**RE: JIFFY LUBE (C-13/D24)**  
**(9386 Valley View Drive)**  
**ENGINEERS CERTIFICATION FOR CERTIFICATE OF OCCUPANCY**  
**ENGINEERS STAMP DATED 12/19/2001**  
**ENGINEERS CERTIFICATION DATED 12/17/2002**

**Re: Jiffy Lube Grading and Drainage Plan**  
**Engineer's Stamp Dated 2-05-02, (C13/D24)**

**Re: Jiffy Lube Grading & Drainage Plan, Coors Blvd & Valley View Drive, Engineer's stamp  
dated 12/19/01 (C13/D24)**

**Re: Jiffy Lube Grading & Drainage Plan, Coors Blvd & Valley View Drive, Engineer's stamp dated 12/13/01 (C13/D24)**

GIFFY LUBE GRADING & DRAINAGE PLAN COORS BLVD. & VALLEY VIEW DR.

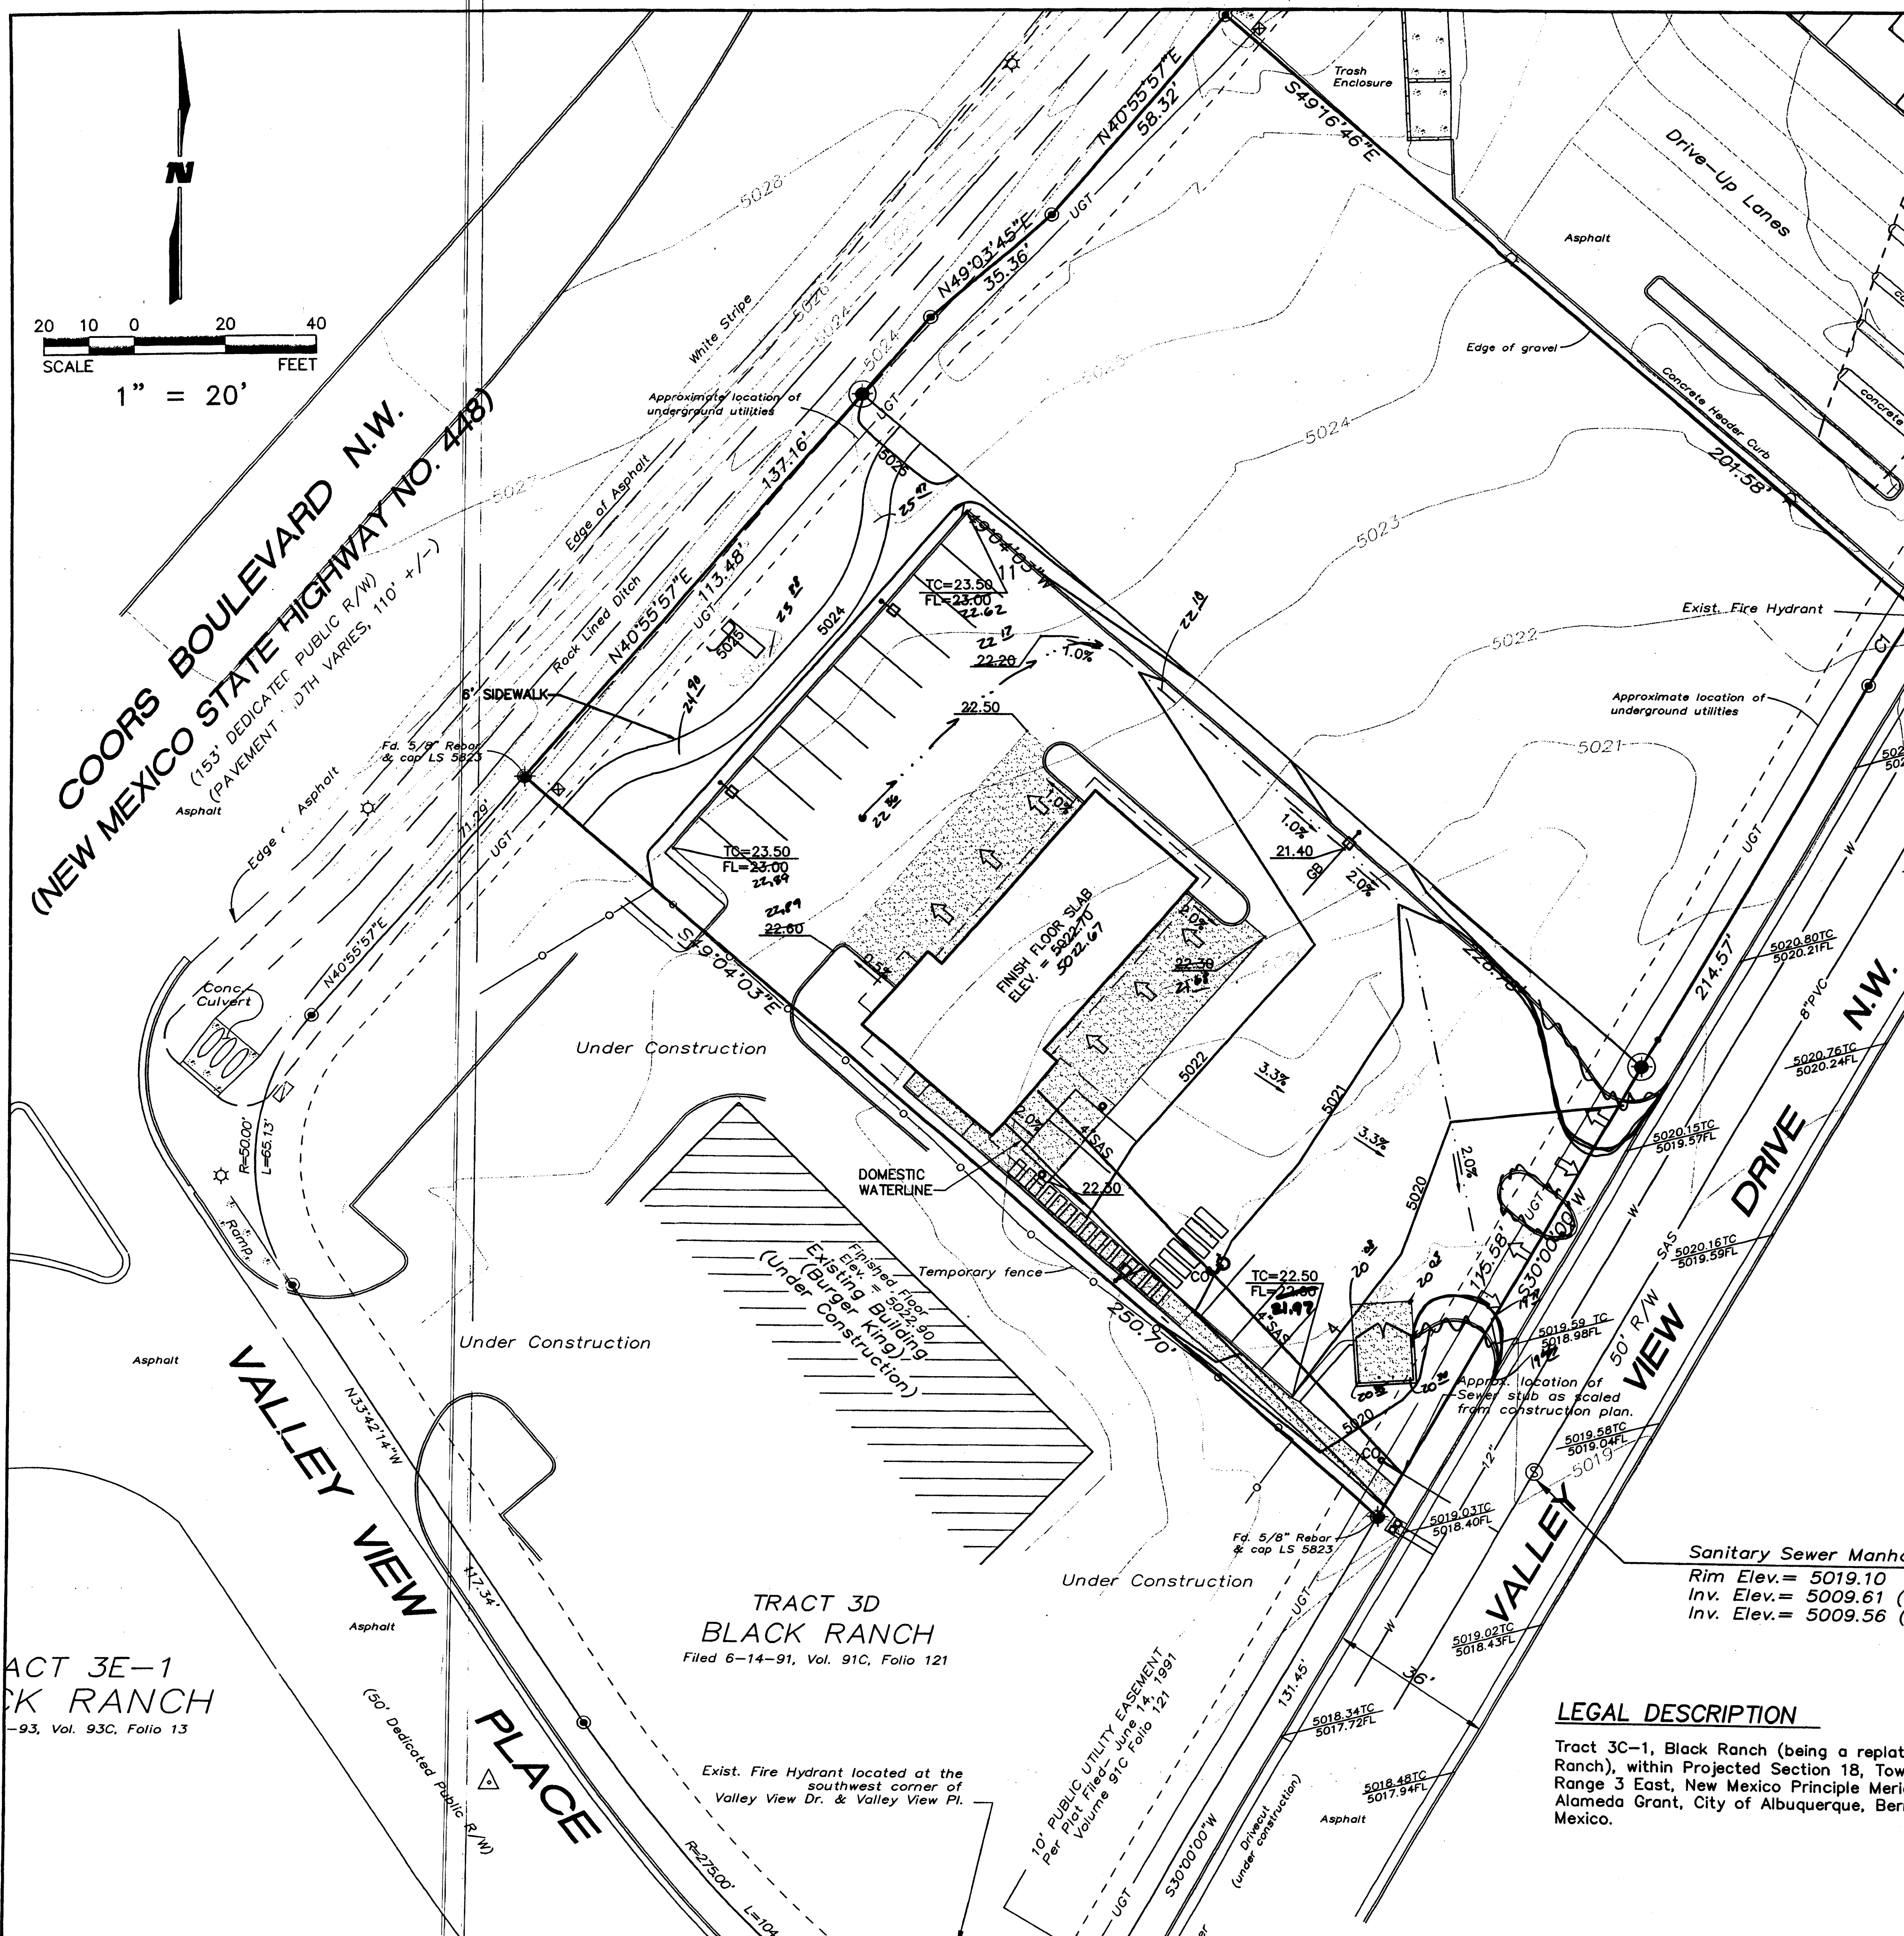
This plan will require more TC/FL spot elevations before you submit for Building Permit approval. If you have any questions, please call me at 924-3988.

1. Please add the correct legal description to the plan. I believe it is Tract 3C-1, Black Ranch.
2. Show the building finish floor elevation to two decimal places.
